**Recommendation:** Refuse

**Applicant:** Debbie Whitford

**Proposal:** Flat roofed single garage

PROPOSED GARAGE AT THE BUNGALOW, WHITE POST ROAD, BODICOTE OX15 4BN for
DEBBIE WHITFORD

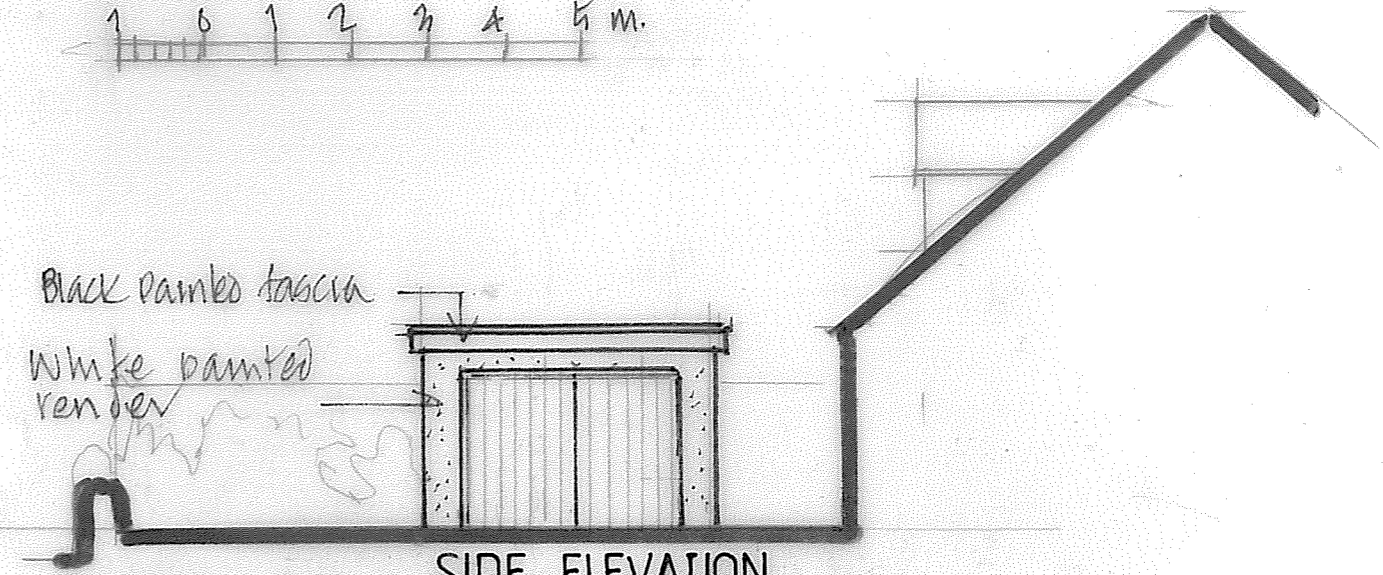
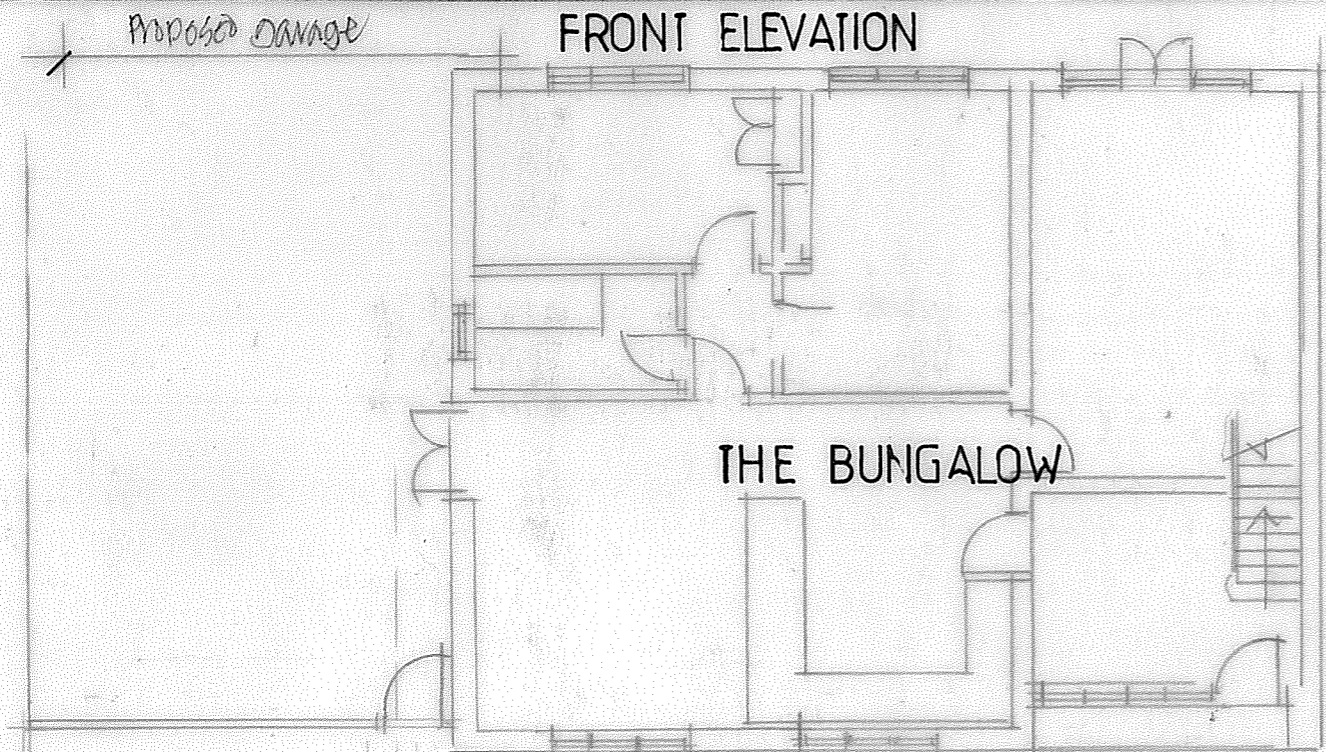
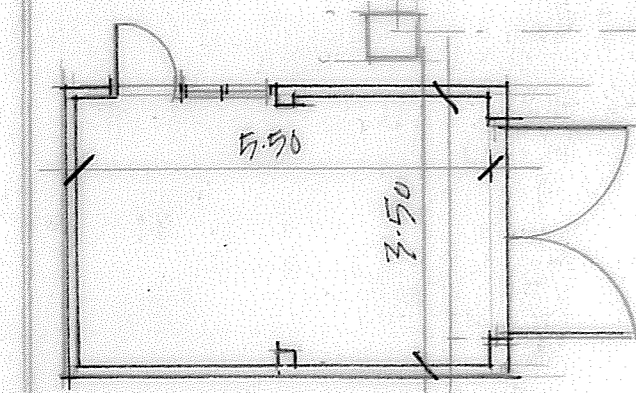
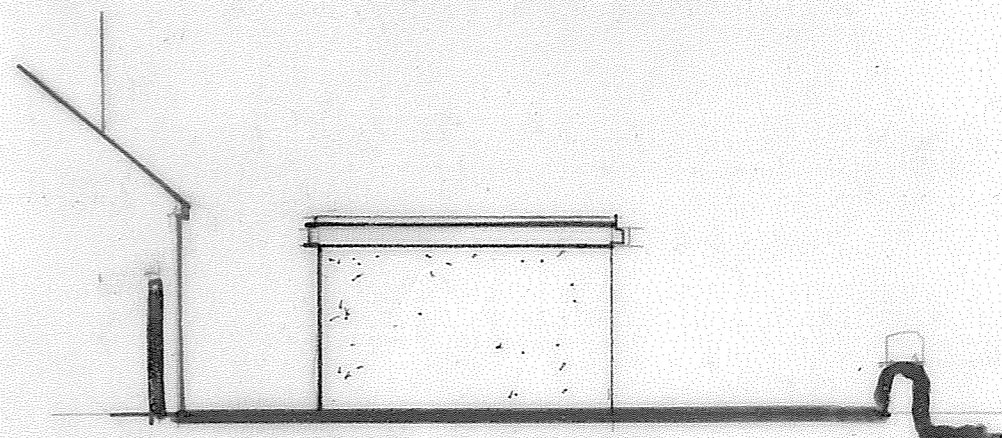
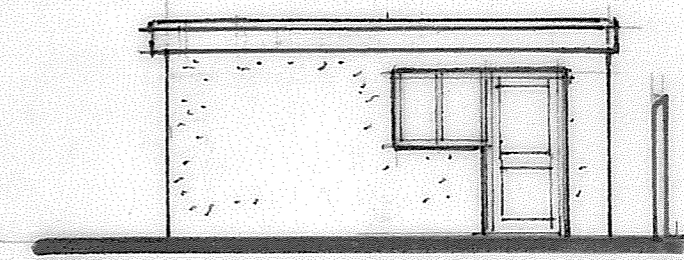
7.3. The proposed garage would be subservient in scale to the dwelling but would be set forward of the host dwelling by approximately (2.7m) and positioned in close

- 7.4. Given its scale and siting the proposed garage would be a very prominent form of development within the local area and would have a significant impact on the character and appearance of the Conservation Area and the significance of listed buildings in the vicinity through change to their setting(s).

- 7.5. Detached garages are not generally supported in locations forward of the principal dwelling, and this is particularly true of Conservation Areas and other visually sensitive locations. In this instance, the impact of the proposal is exacerbated by its form and the proposed materials.

- 7.6. By reason of its scale, siting, form and appearance, it is considered that the proposed garage would result in significant and demonstrable harm to the character and appearance of the Conservation Area and to the significance of the nearby listed buildings through change to their setting. Given the garage would not affect the fabric of the listed buildings or result in the demolition of the listed building, the identified harm is *less than substantial*. Given its siting forward of the front elevation there is no fallback position for the proposed development.

- 7.7. By reason of its scale, position and its appearance and occupying a prominent position, the proposed garage to the front of the dwelling would be out of keeping with the prevailing pattern of development in the locality. The proposal would be an incongruous addition which would result in the detriment to the visual amenity of the street scene by appearing overly prominent and would set an unwelcome precedent for the development in the local area. The development would therefore cause significant and demonstrable harm to the visual amenity of the area.

1. The proposed development, by virtue of its scale, siting, and design, would result in a visually incongruous form of development that would appear overly prominent within the street scene, would be out of keeping within the prevailing pattern of development in the locality and would result in significant and demonstrable harm to the character and appearance of the local area and would set an unwelcome precedent in the local area. For the same reasons, the proposed development would fail to preserve the significance of the listed buildings to the east and south through change to their setting and would fail to preserve the character and appearance of the Bodicote Conservation Area. This harm, which would be *less than substantial*, is not outweighed by any public benefits. The proposed development therefore fails to accord with Policy ESD15 of the Cherwell Local Plan 2011-2031 Part 1 and Government guidance contained in the National Planning Policy Framework and Cherwell District Council's Home Extensions and Alterations Design Guide (2007).

- 7.9. The case officer has discussed these concerns with the applicant's agent, and suggested ways to address them, either by relocating the garage to be to the side of the dwelling, or by facing the walls of the garage (with the exception of the doors) in natural stone. In the case of the latter option, there would continue to be a very significant impact on the character and appearance of the area, but officers consider on balance it would be sufficiently mitigated by the locally distinctive materials, visible in the dwelling opposite, the listed building to the south, and the walls to the front boundary of properties in the locality, which would help to integrate the awkwardly formed/massed building into its surroundings.
